From: [REDACTED]
To: [M25 Junction 28](#)
Cc: [REDACTED]
Subject: London Borough of Havering Deadline 3b Submission TR010029 - Responses to Deadline 3a submissions
Date: 25 February 2021 19:34:34
Attachments: [LBHaveringResponsetoDeadline3aSubmissions25022021.pdf](#)

Please find attached the London Borough of Havering (20025659) submission for Deadline 3b for the M25 J28 Improvement Scheme (TR010029). This submission concerns LB Havering's Responses to Deadline 3A submissions.

**London Borough of Havering (20025659) – Responses to Deadlines 3a submissions
REP3A-019, REP3A-020, REP3A 022.**

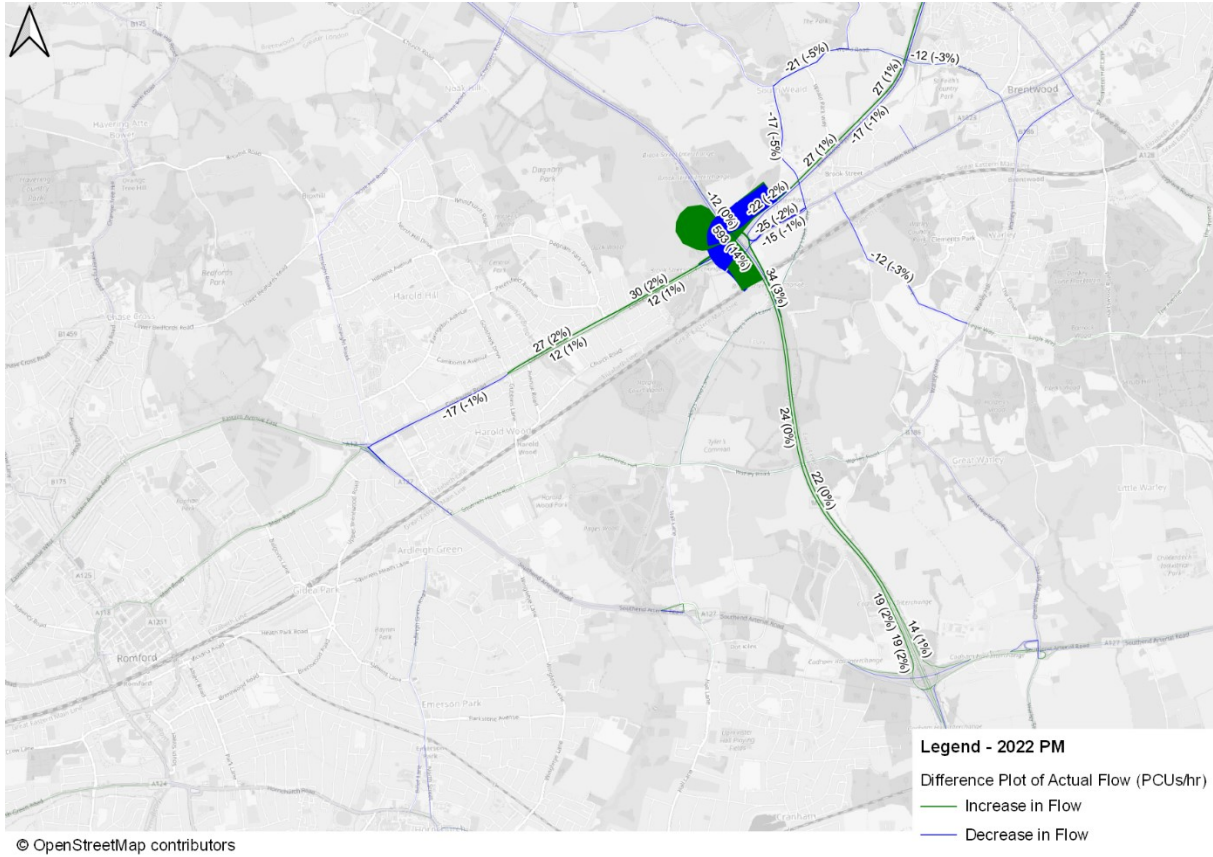
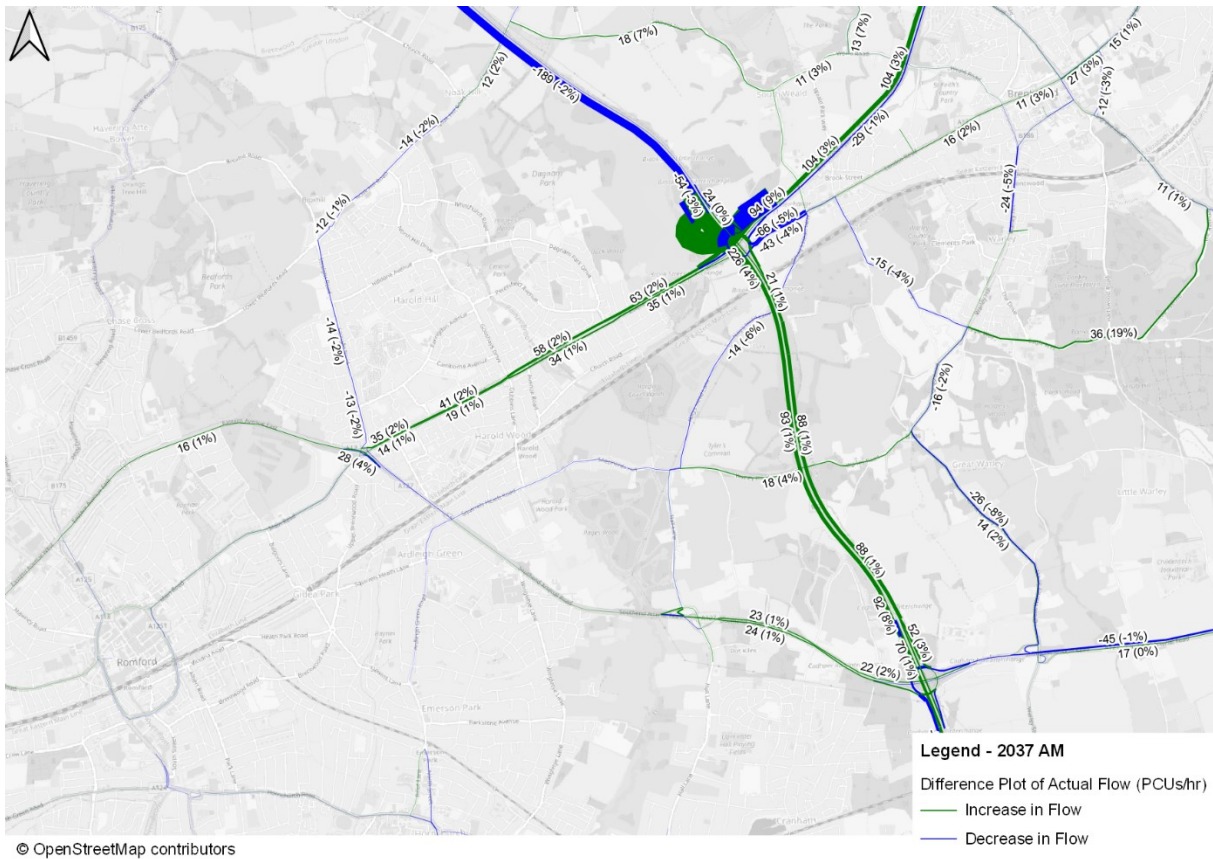
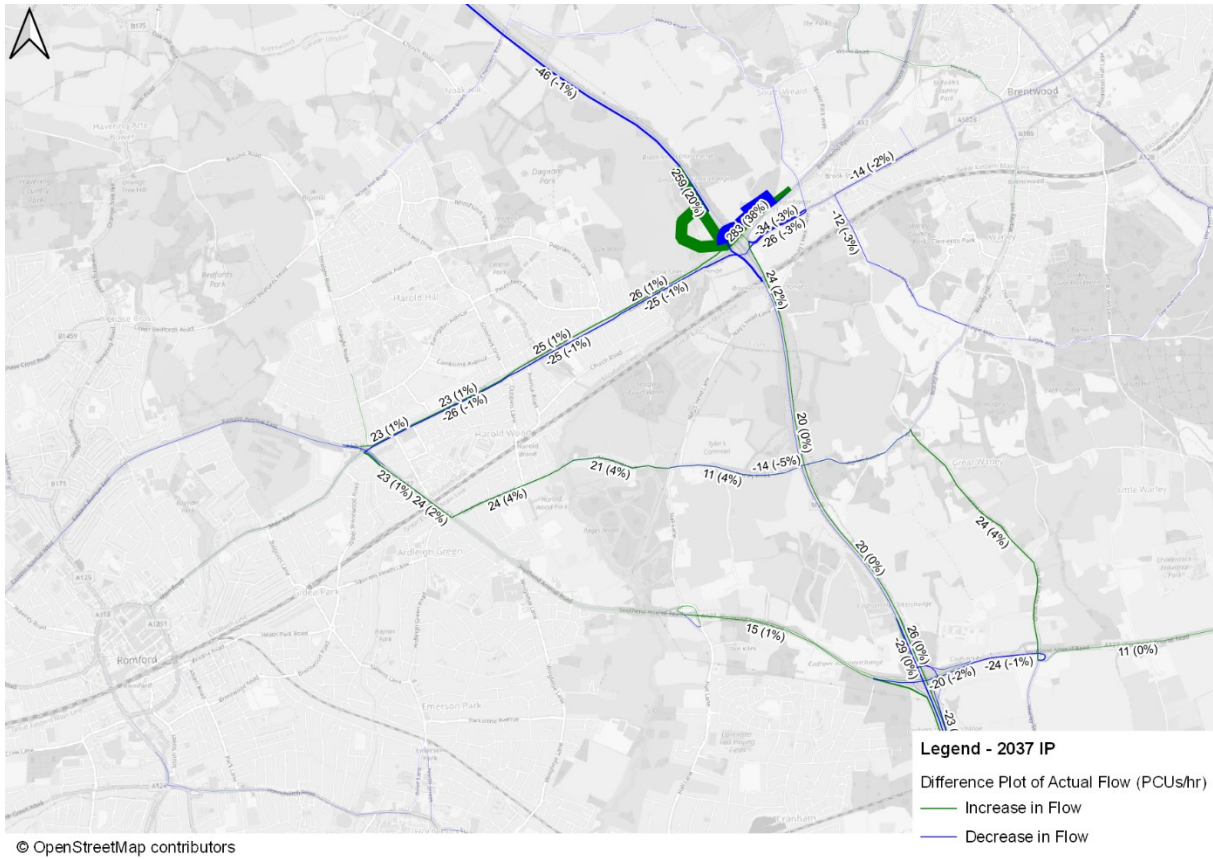
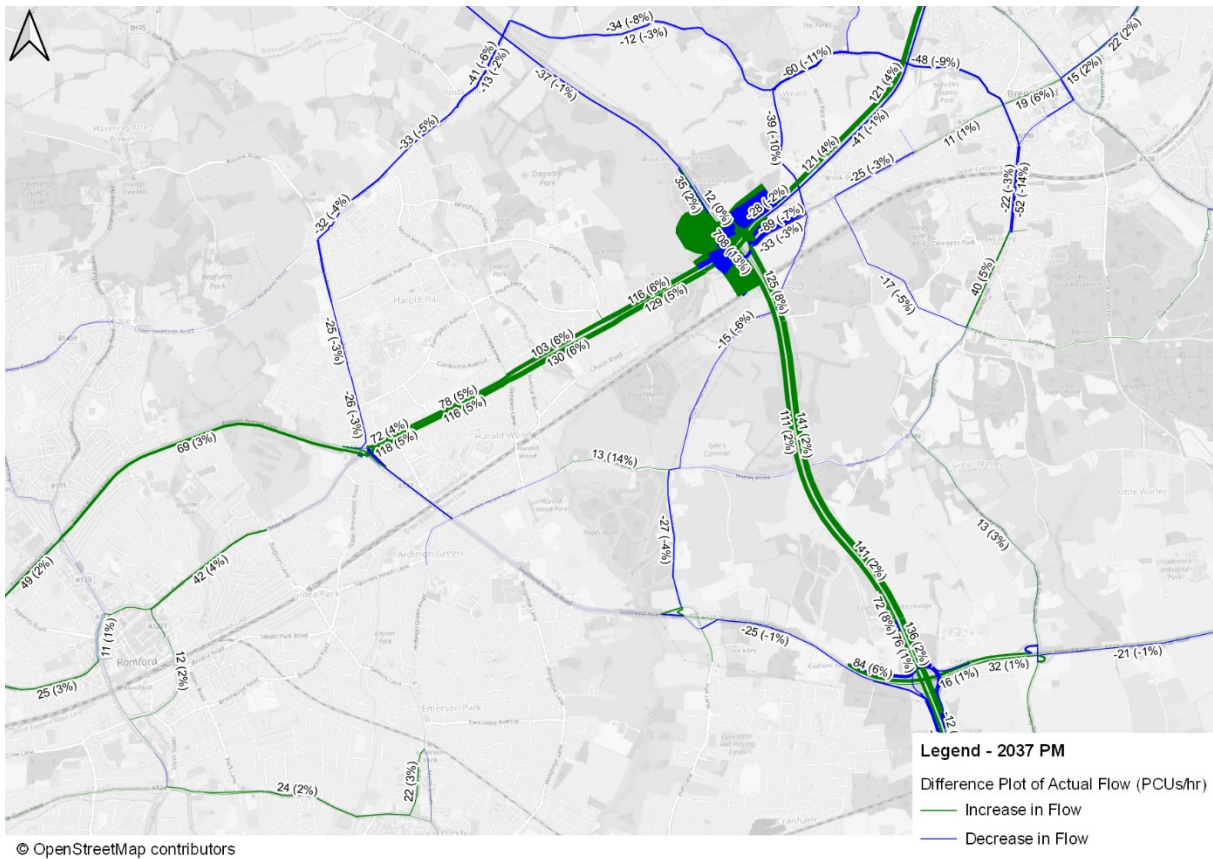
LBH do not concur with the Applicant that the wider local road network has been assessed. The Applicant admits this very point in TR010029.9.5 Transport Assessment Supplementary Information Report in paragraph 4.1.2 – *“As explained in Section 3 of the Transport Assessment Report [APP-098], the traffic models used to evaluate the traffic impacts of the Scheme consist of a strategic traffic assignment model that covers the road network over a large area around the north east quadrant of the M25, including Gallows Corner junction, and a more detailed (VISSIM based) operational traffic model that covers the road network in the immediate vicinity of M25 junction 28 (and the Scheme), **but does not include Gallows Corner junction nor the local road network in the vicinity of Gallows Corner junction**”*.

The extent of the VISSIM based operational model was determined based on the strategic traffic model assignments which showed that the changes in traffic flows on the road network at, and in the vicinity of, Gallows Corner junction due to the Scheme are forecast to be small, therefore indicating that the Scheme would not have a significant impact on the operational performance or capacity of this part of the road network.”. The concerns that LBH has regarding understanding the impact on the local road network are maintained.
